Wood Green Animal Shelter, King's Bush Farm, Godmanchester

APPLICATION BY HIGHWAYS ENGLAND FOR AN ORDER GRANTING DEVELOPMENT CONSENT FOR THE A14 HUNTINGDON TO CAMBRIDGE IMPROVEMENT SCHEME (TR010018)

Written Representations – Deadline 2 (Ref: 10030873)

Drawing title: **RIGHTS OF WAY & ACCESS PLANS REGULATIONS 5(2)(k) & 5(2)(c) SHEET 11 OF 28**

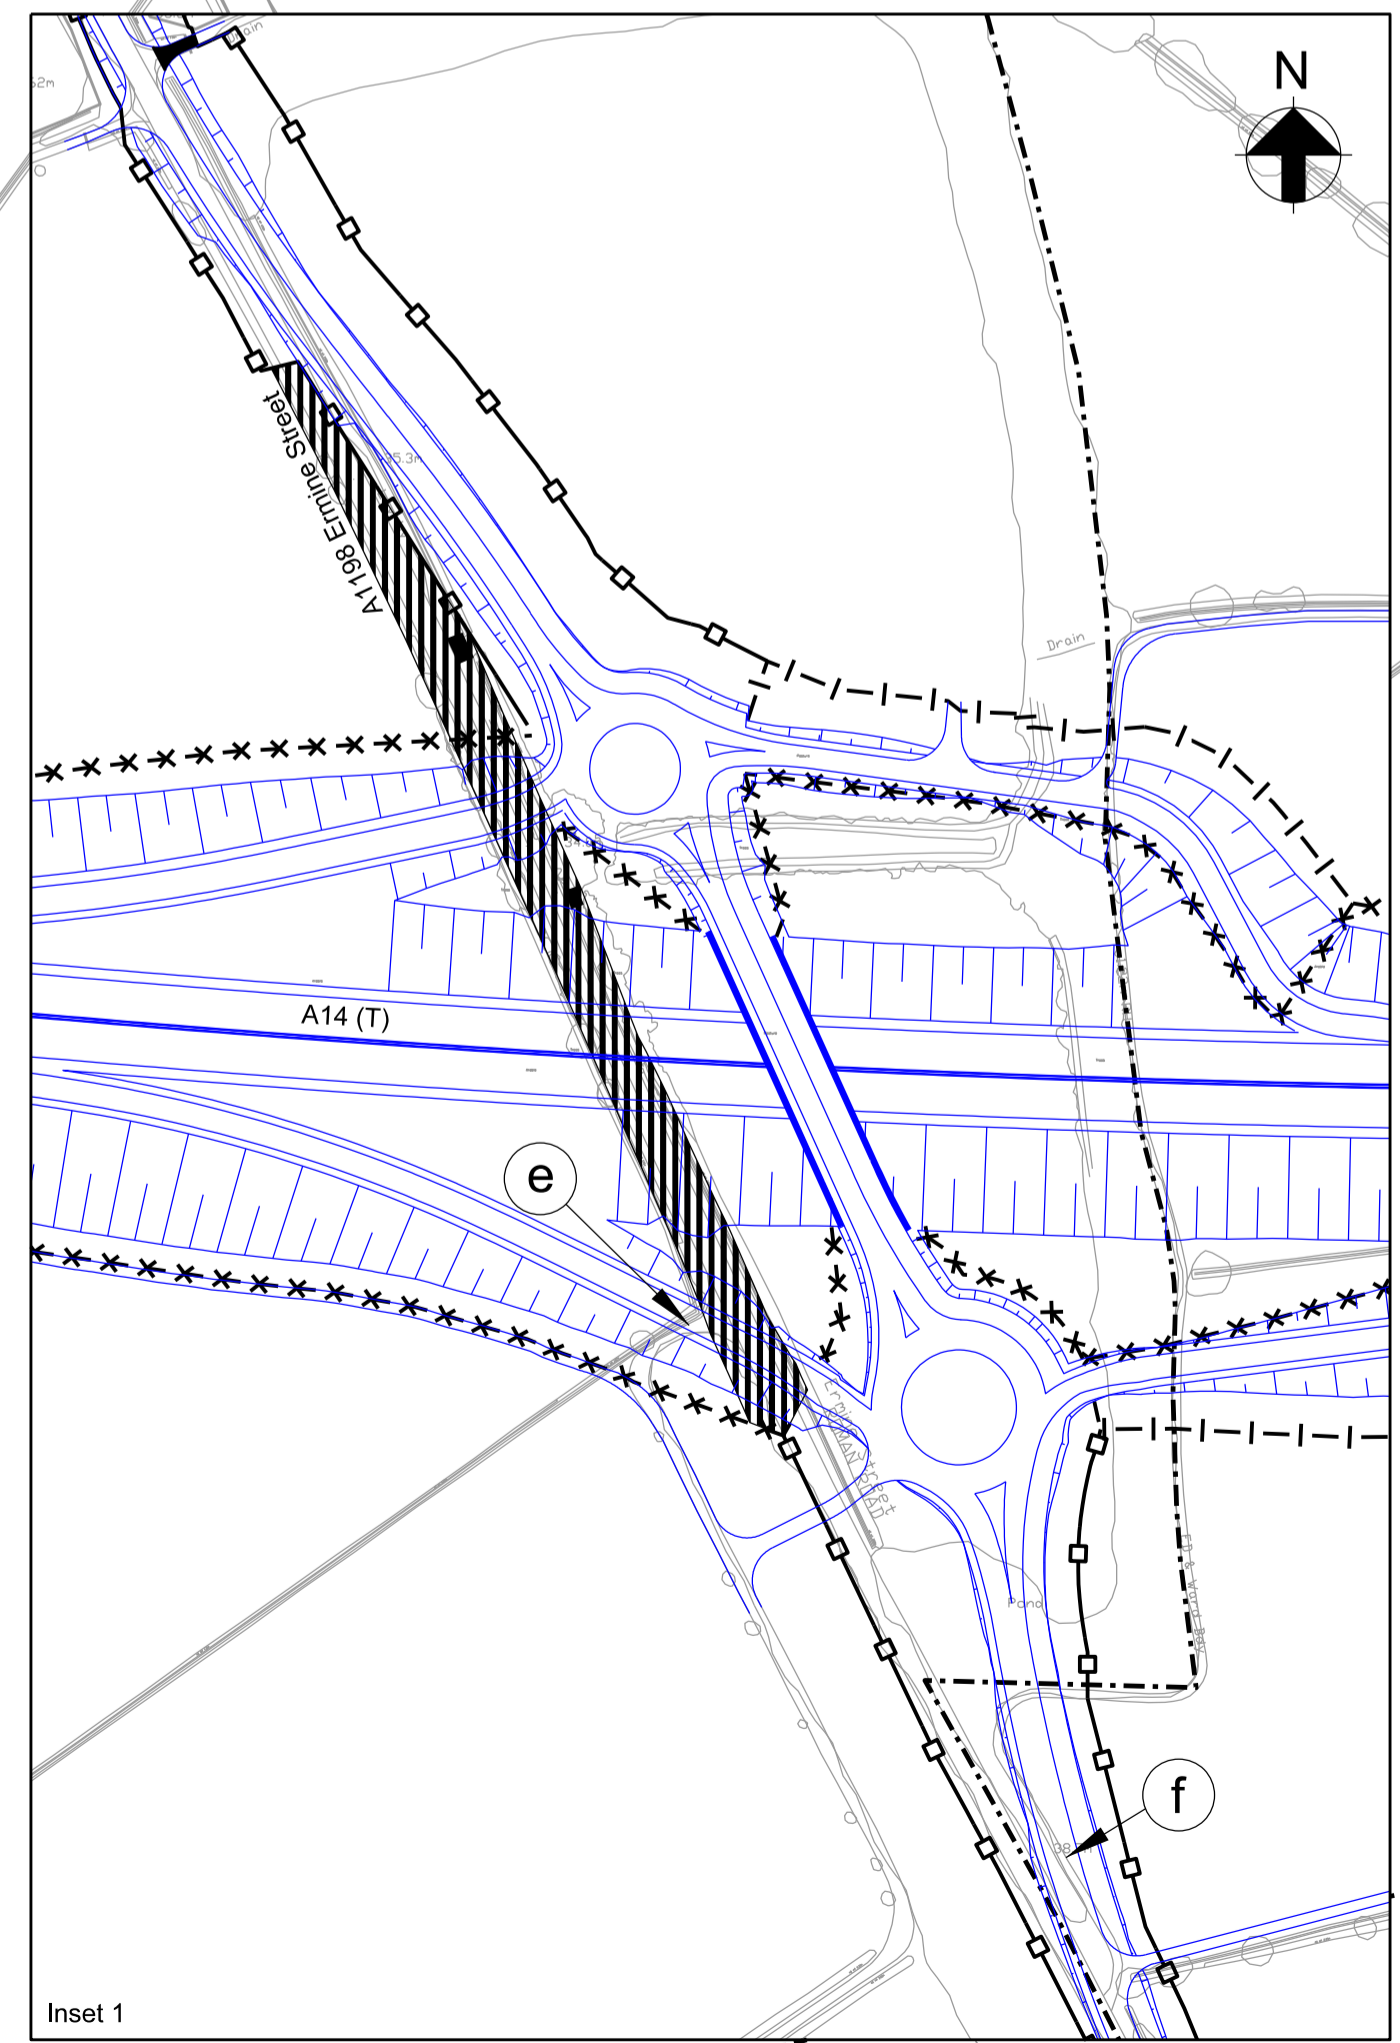
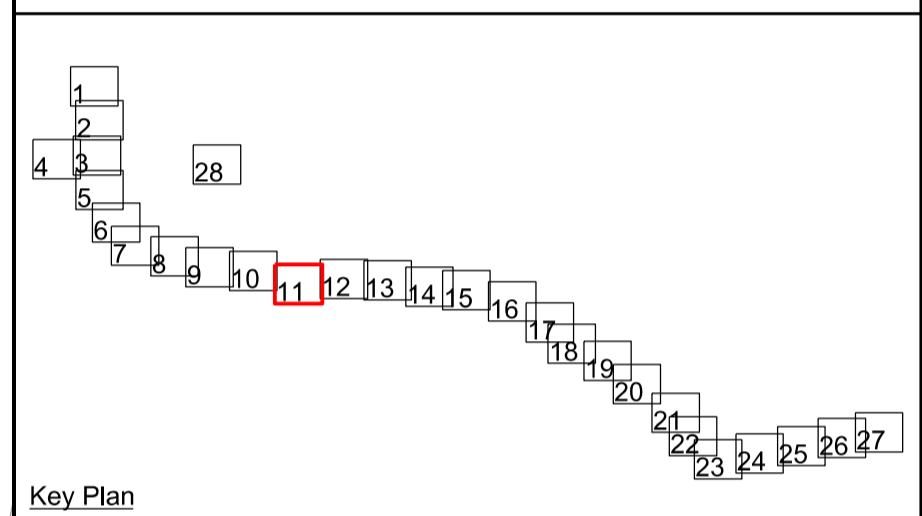
These written representations relate to the proposed stopping – up of the points of egress from the Wood Green site as illustrated in the Jacobs drawing (number A14-ARP-ZZ-00-DR-Z00311 Rev 1) '*Rights of Way and Access Plans regulations 5(2)(k) and 5(2)(l) Sheet 11 of 28*' that define at Point 2(a) and 2(b) the existing and new private means of access. Our client is content that the works do not result in the closure of these points of egress, but simply draws attention to the levels of activity at Wood Green during key times of the year and requests that adequate and suitable consultation occurs to minimise any impact of visitors during the period of construction.

We would be very grateful for confirmation that the works will not affect the operation of Wood Green and that during the construction process, our client will be consulted on matters such as the duration of the works and their timing.

Our client will discuss matters such as the effect of any traffic changes in Ermine Street with the County Council and will also seek clarification on matters related to the proposals for a new public right of way or public footpath that appears to terminate in the vicinity of Wood Green.
